The Drovers Solar Farm

Statement of Common Ground (SoCG) with Environment Agency (Clean)

PINS reference: EN0110013

Document reference: APP/5.13.1 (Revision 1)

Drawing file: published-documents / EN0110013-000144-6.3 ES Figure 12.13 Work No.2 Piling Locations within CSA for Maximum Groundwater Level.pdf

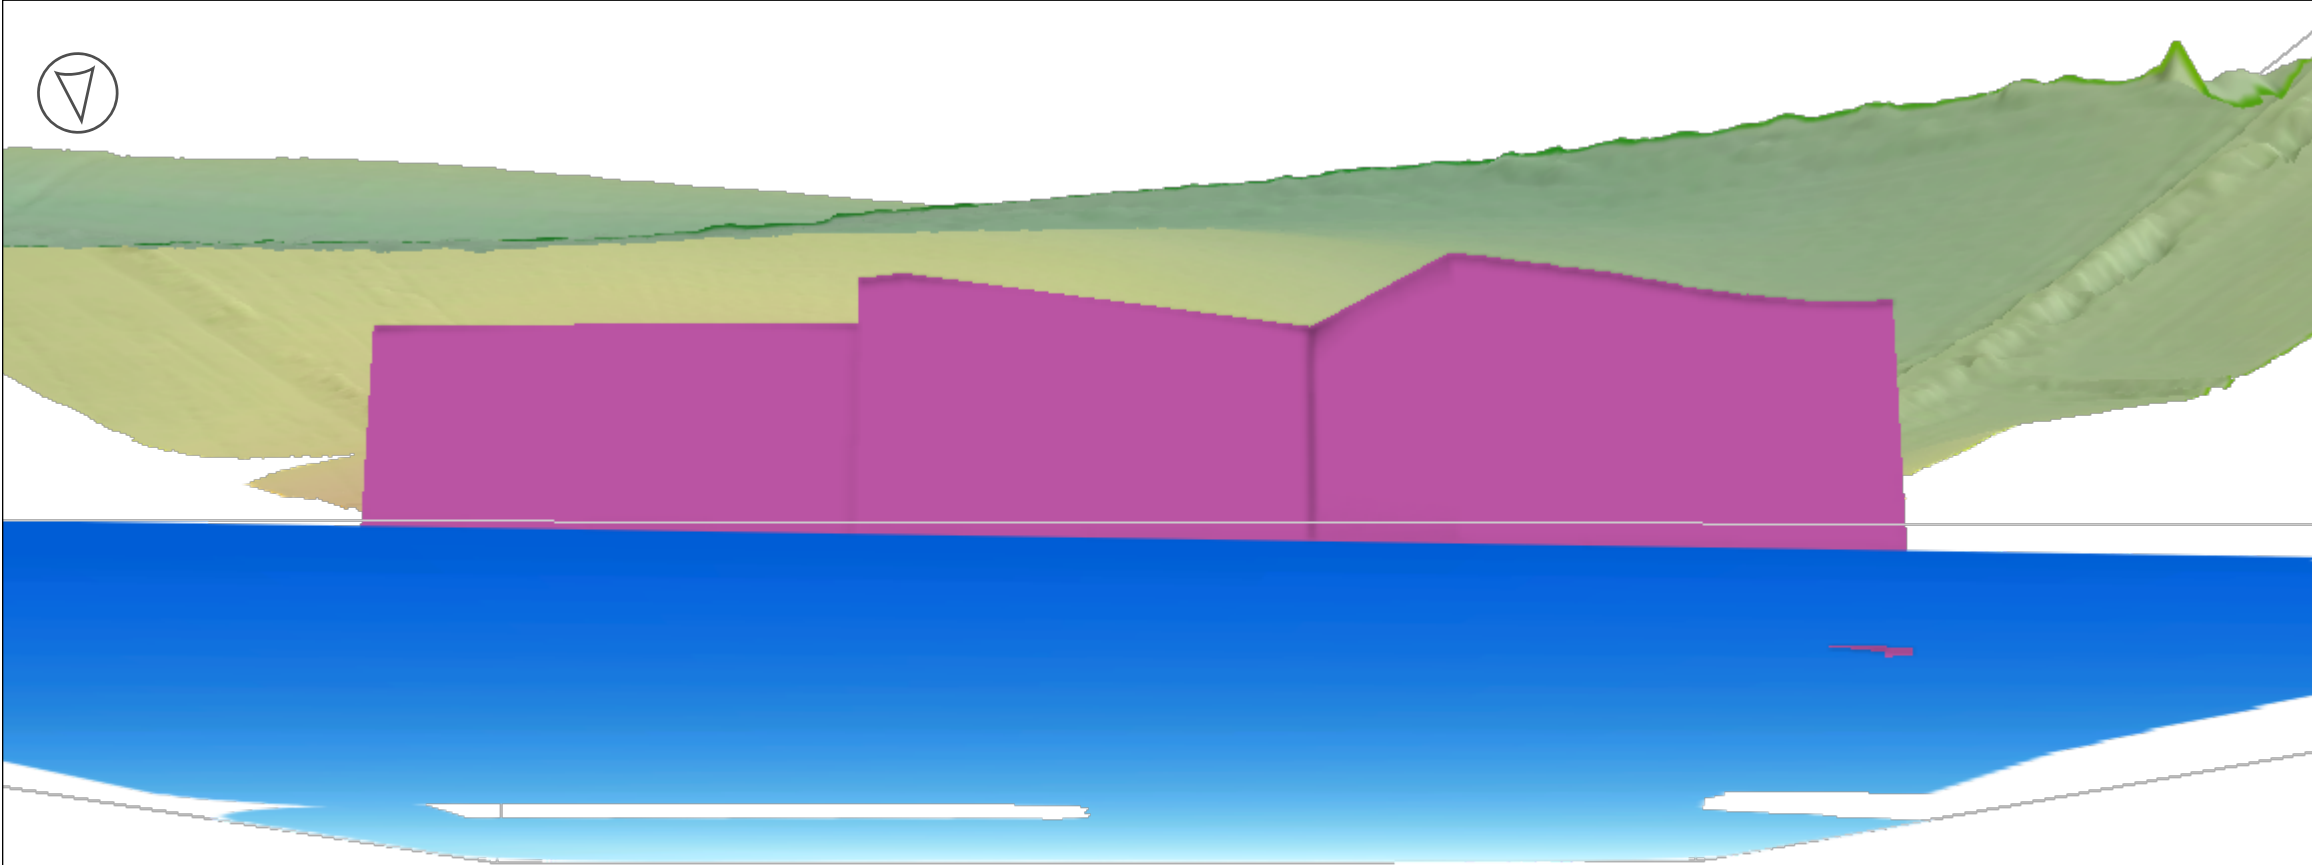
Reference	EA Issue Reference	Topic	Consultee's Position	Applicant's Position	Status
2-1	EA05	Maximum Foundation Extents	Figure 12.13 Work No.2 Piling Locations within CSA for Maximum Groundwater Level [APP-127] Figure 12.14 Work. No 3 Piling Locations within CSA for Maximum Groundwater Level [APP-128] Figure 12.15 Work No. 4 Piling Locations within CSA for Maximum Groundwater Level [APP-129] Figure 12.16 Maximum Foundation Extents for Minimum Groundwater Level [APP-130] Issue: Figures 12.13 to 12.16 do not clearly show the orientation of each 3D model view,	Figures 12.13 to 12.16 of ES Chapter 12: Water Resources [APP-061] were used to illustrate the maximum groundwater elevation surface across the Core Study Area and identify where proposed foundation depths could theoretically intercept shallow groundwater under worst-case conditions. The figures also demonstrate at a concept level where piling may be required depending on foundation design. The following changes have been made at Deadline 3 to aid the EA's interpretation: Addition of orientation labels or description	Medium

and the elevation of the maximum extent of foundations is not given. Impact: Difficulty in interpreting figures. Solution: Revise figures to more clearly define the area represented in the drawings, including view orientation, and the maximum foundations extent should be shaded to show elevation values. The model should be updated to inform detailed foundation design, based on site specific survey and monitoring data. Additional Comments: Use of inconsistent terminology may also result in confusion. Figures 12.13 to 12.15 are titled to show the anticipated extent of piling in comparison with the maximum groundwater level. In the context of the data presented, the maximum groundwater level in mAOD represents the shallowest extent and therefore worst-case condition for groundwater. For clarity the report should preferably refer to groundwater 'elevation' (in mAOD) as is represented within the figures rather than 'level', which could be misinterpreted as relative to ground level rather than Ordnance Datum. Figure 12.16 shows the minimum (i.e. deepest) groundwater elevation (i.e. best case) in relation to anticipated piling depth. Although this is useful information, this could potentially be misinterpreted by the reader as presenting a combined overview of the	- Elevation shading to show mAOD values for the maximum groundwater elevation surface and foundation extent surface - Highlight areas where foundations intersect or exceed groundwater elevation surfaces; and - Figures and text refer to groundwater elevation (mAOD) rather than groundwater level to increase clarity between absolute elevation and depth below ground. The Applicant agrees that the conceptual model present is not the final tool for foundation design, but rather to provide a screening-level assessment of groundwater conditions and to identify areas needing piled or shallow foundations and will be aligned with EA regional groundwater understanding (NEAC model). The Design Principles, Parameters Commitments [APP/5.8.3] have been updated at deadline 2 to commit to foundations not directly interacting with groundwater.

DRAWING TITLE:
ES Figure 12.15 Work No. 4 Piling Locations within
CSA for Maximum Groundwater Level

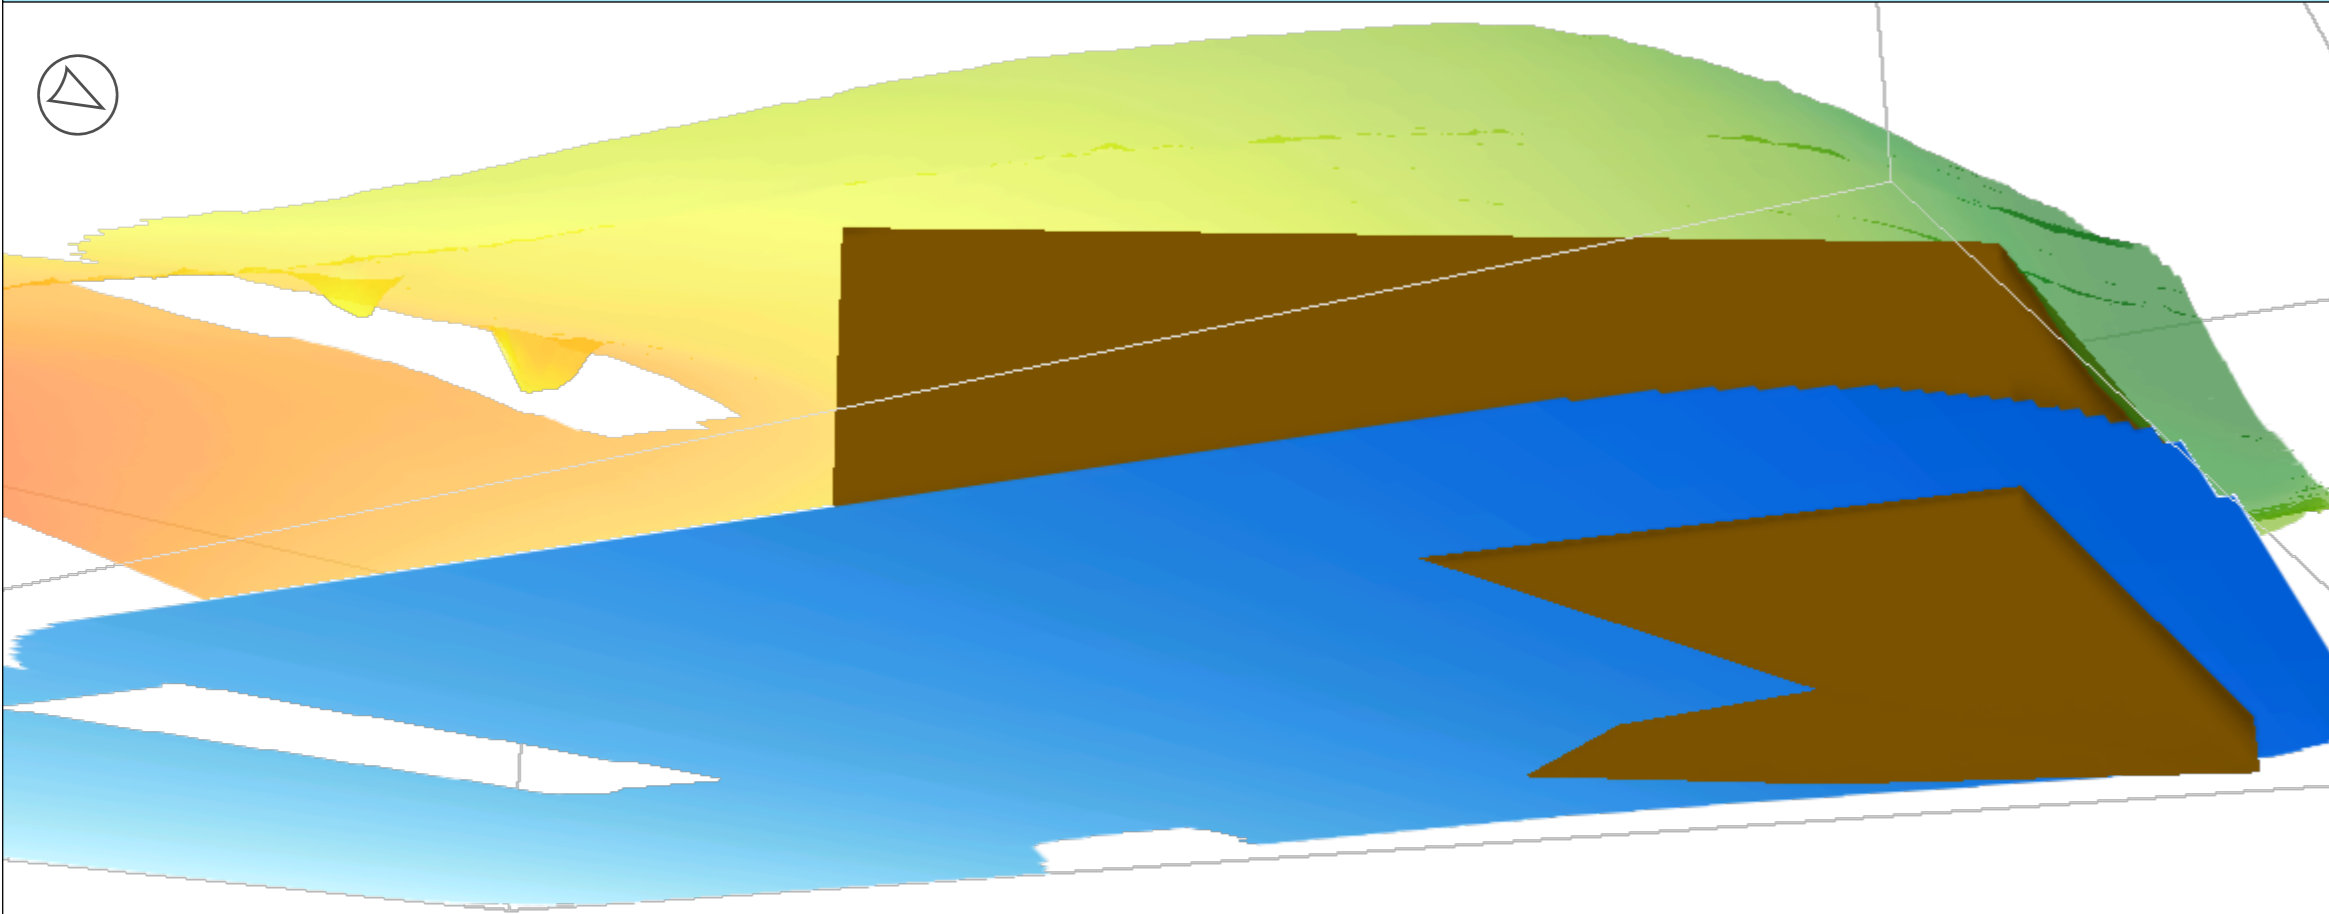
Figure 12.15 Work No. 4 Piling Locations within CSA for Maximum Groundwater Level [APP-129] Figure 12.16 Maximum Foundation Extents for Minimum Groundwater Level [APP-130] Environmental Statement Chapter 12: Water Resources [APP-061], Sections 12.6.9, 12.6.37 and 12.6.38 Issue: Estimated groundwater flow direction across most of the draft Order Limits area is indicated to be toward the north-east, north or northwest, approximately following local topography. Impact: Groundwater flow direction as indicated in Figures 12.7 to 12.16 may be inaccurate. Solution: Claims such as that made in Sections 12.6.37 and 12.6.38 regarding potential groundwater interception should be revised and new evidence, preferably across multiple lines, sought to support them. Intrusive investigation to measures groundwater level with empirical evidence is highly recommended. Additional Comments: The majority of the draft Order Limits area is shown to be underlain directly by Chalk Principal aquifer, and according to Chapter 12 Section 12.6.9, trial trenching activities in the vicinity of the proposed BESS and substation sites did not	where interception risk across the Work Nos. 1 to 4 during construction could occur. They were not intended to be used as a regional groundwater flow model. Paragraphs 12.6.37 and 12.6.38 of ES Chapter 12: Water Resources [APP/6.2.2] have been updated at Deadline 2 to remove any implied statements of groundwater flow direction across the Order limits and present the Applicant's findings are local-scale interpretations. Reference to the Environment Agency's NEAC model and BGS hydrogeological mapping in regard to regional groundwater flow will be made to consolidate the conceptual groundwater model of the Scheme. Paragraph 12.8.23 of ES Chapter 12: Water Resources [APP-061] commits to installing boreholes within the Order limits to monitor groundwater levels prior to construction to ensure that construction activities such as HDD and foundations do not occur when groundwater levels are high enough to interact with the activity. The Applicant has requested the Environment Agency's NEAC model and this will be used to further refine groundwater elevations within the Order limits at a subsequent Deadline, noting that <i>"the Applicant's estimations are within a similar</i>

Drawing file: published-documents / EN0110013-000634-6.3.1 ES Figure 12.10 Groundwater Flow Directions from NEAC Groundwater Model.pdf

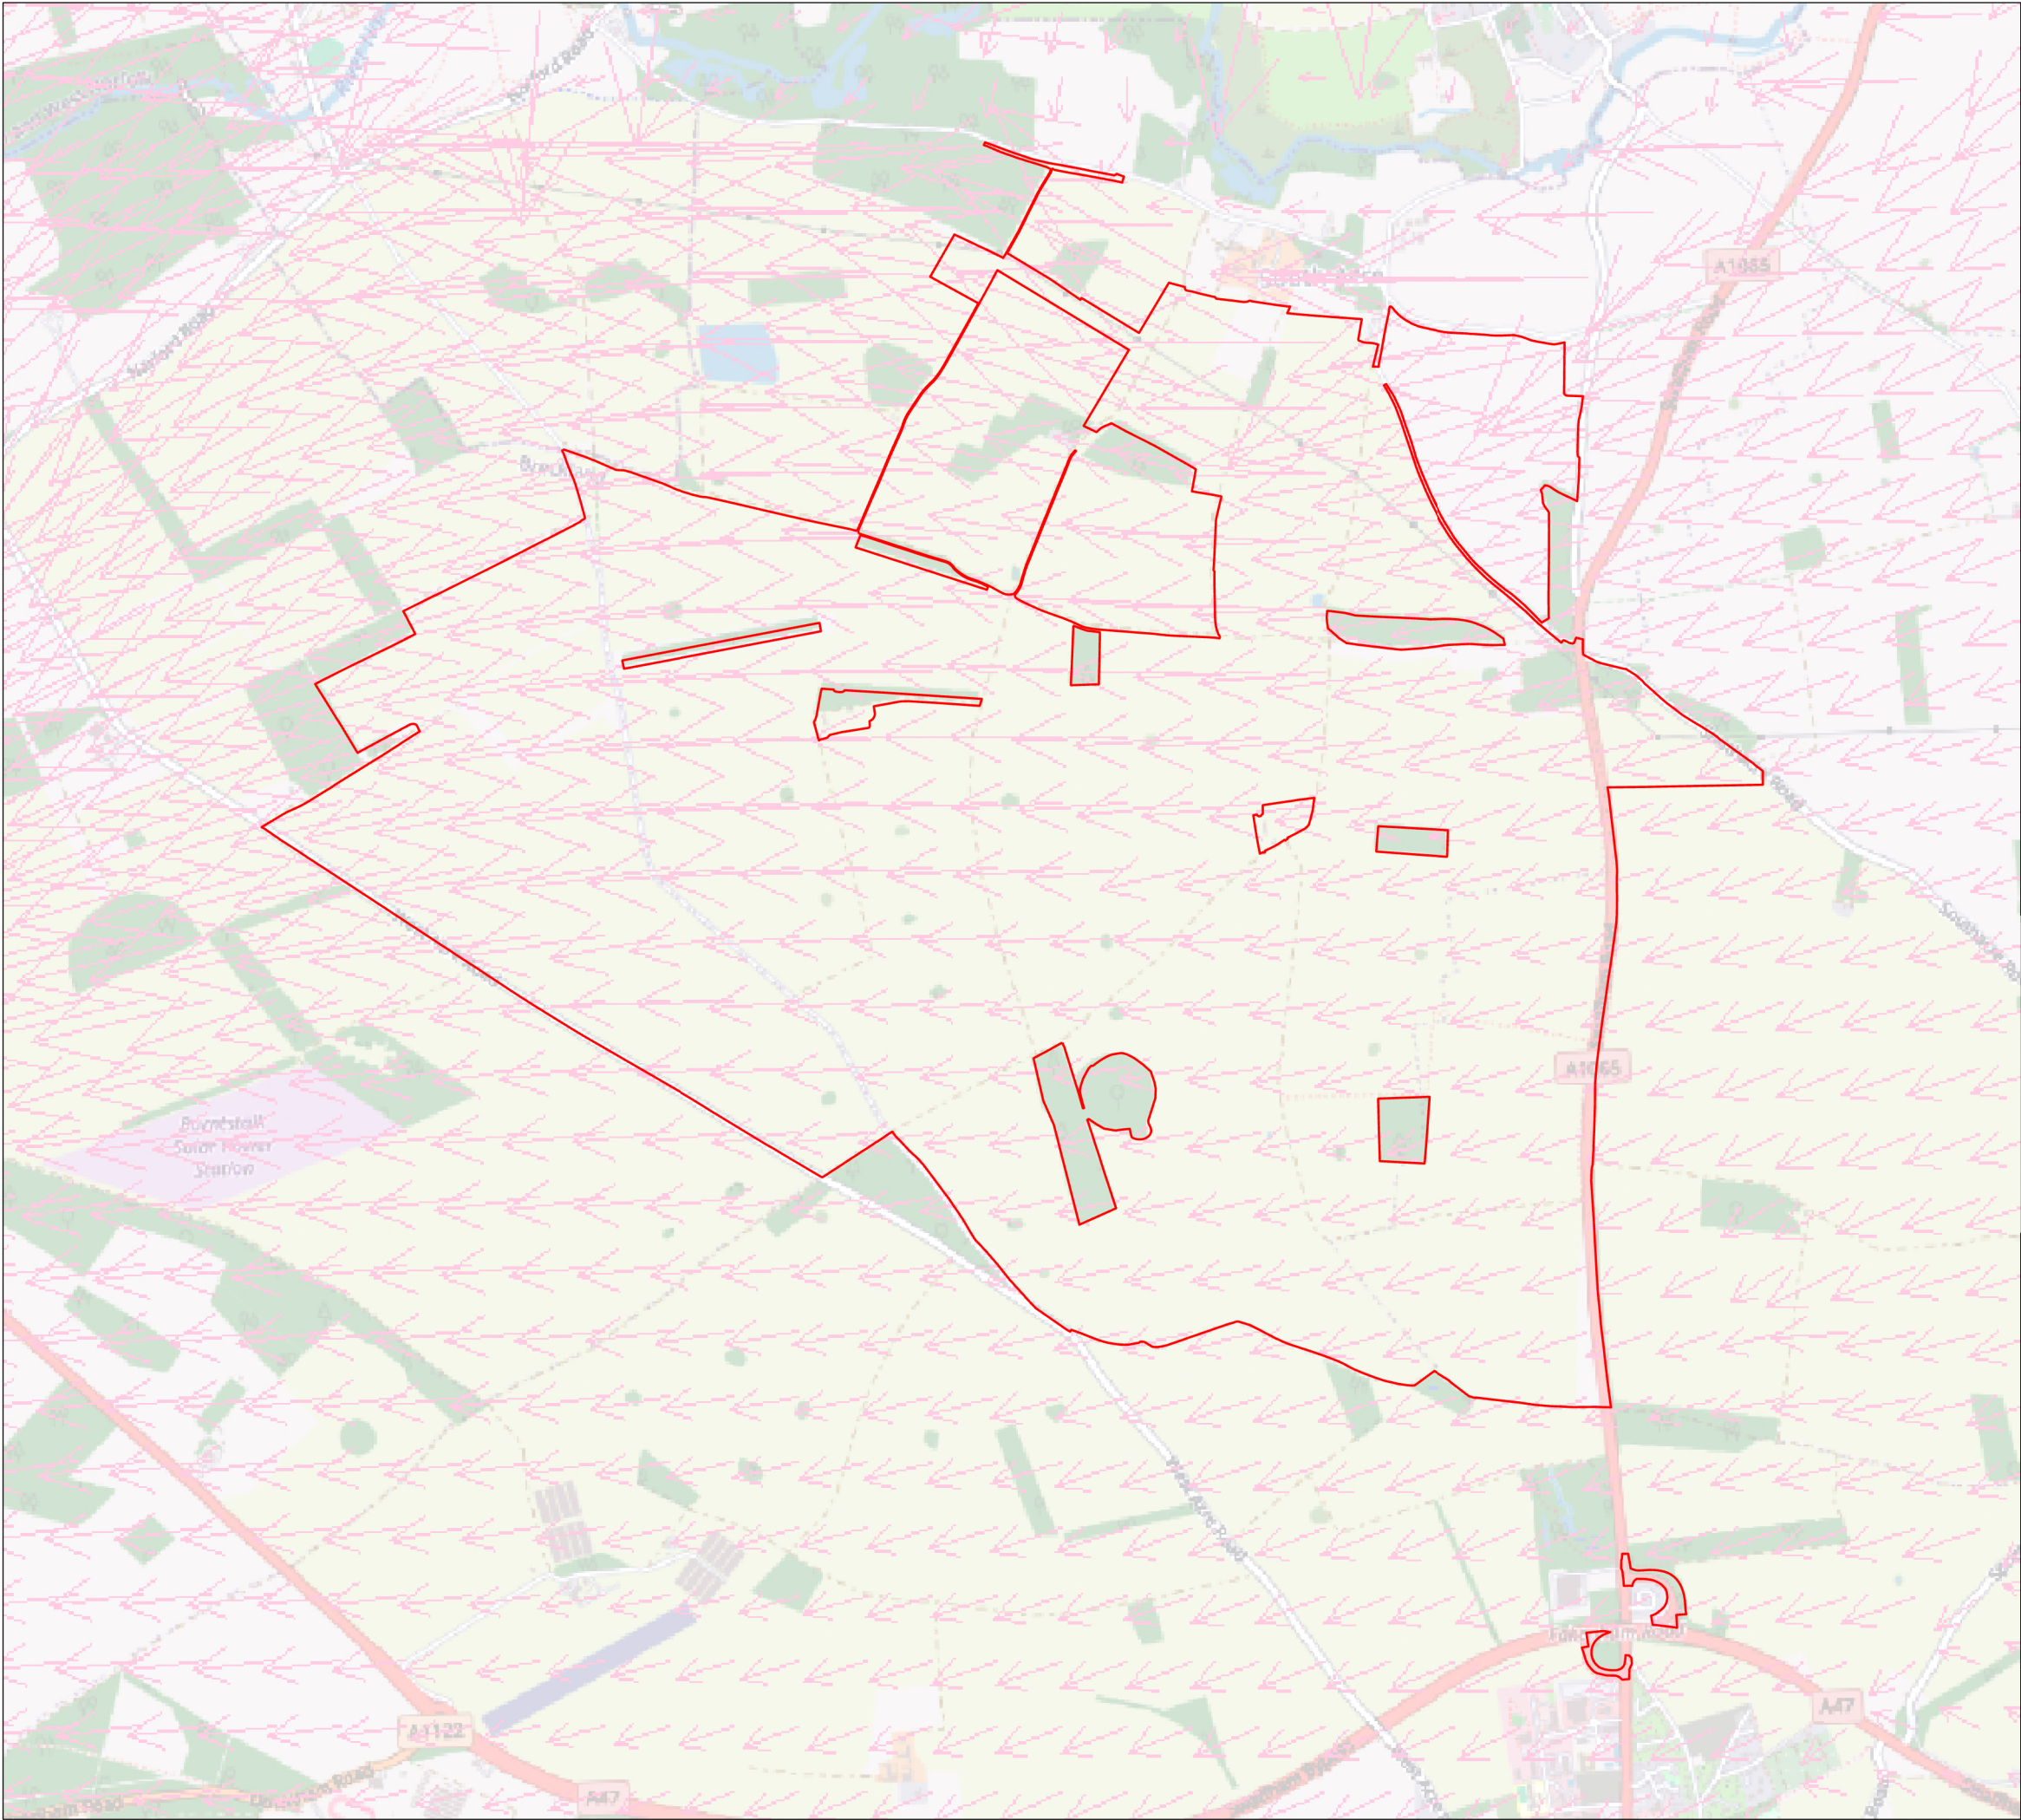
encounter superficial deposits. The draft Order Limits area lies within Zone 1 and Zone 2 of a groundwater SPZ for a potable water abstraction at Marham, located to the west of the draft Order Limits area. This indicates that groundwater within the Principal aquifer in this area is anticipated to migrate toward the abstraction point to some degree. A review of the 1976 British Geological Society (BGS) Hydrogeological Map of Northern East Anglia (British Geological Survey (BGS) large image viewer IIPMooViewer 2.0) indicates that the potentiometric groundwater upper surface within the Chalk principal aquifer in the vicinity of the site is locally northward toward the River Nar valley but more generally toward the west in the direction of the Marham public water supply abstraction. This is shown in the BGS map as ranging from approximately 30m Above Ordnance Datum (AOD) in the east to approximately 15m AOD in the west. The model outputs produced by the Applicant can be compared to the outputs for various hydrological scenarios available from the Environment Agency's North East Anglian Chalk (NEAC) model, a bespoke groundwater model using MODFLOW 5 which covers most of East Anglia.	<i>range of values for most of the Study Area". As such, the Applicant does not anticipate the outcome of ES Chapter 12: Water Resources [APP-061] to change.</i>

The outputs for a wet month Scenario (March 2001 – corresponding to the Applicant's 'worst-case' data usage of highest recorded levels) show very different groundwater contours and resultant flow directions compared with those produced by the Applicant. Flow in the Chalk is east-to-west in the NEAC model data, rather than south-to-north using the Applicant's techniques derived from individual boreholes nearby. Northwards flow is present locally near the left bank of the Nar, but this reflects the topography close to the Nar intercepting the westerly flowing groundwater. If modelling will be used in the future, the Applicant is advised to consider groundwater flow on a more regional level rather than overfitting a model to a low number of interpolated datapoints. They may also choose to request model runs done on the Environment Agency's NEAC model which can run scenarios designed and paid for by the Applicant. Although the Applicant's estimations are within a similar range of values for most of the Study Area, the figures provided from their modelling should not be accepted as an accurate representation of subsurface groundwater elevation or flow direction.
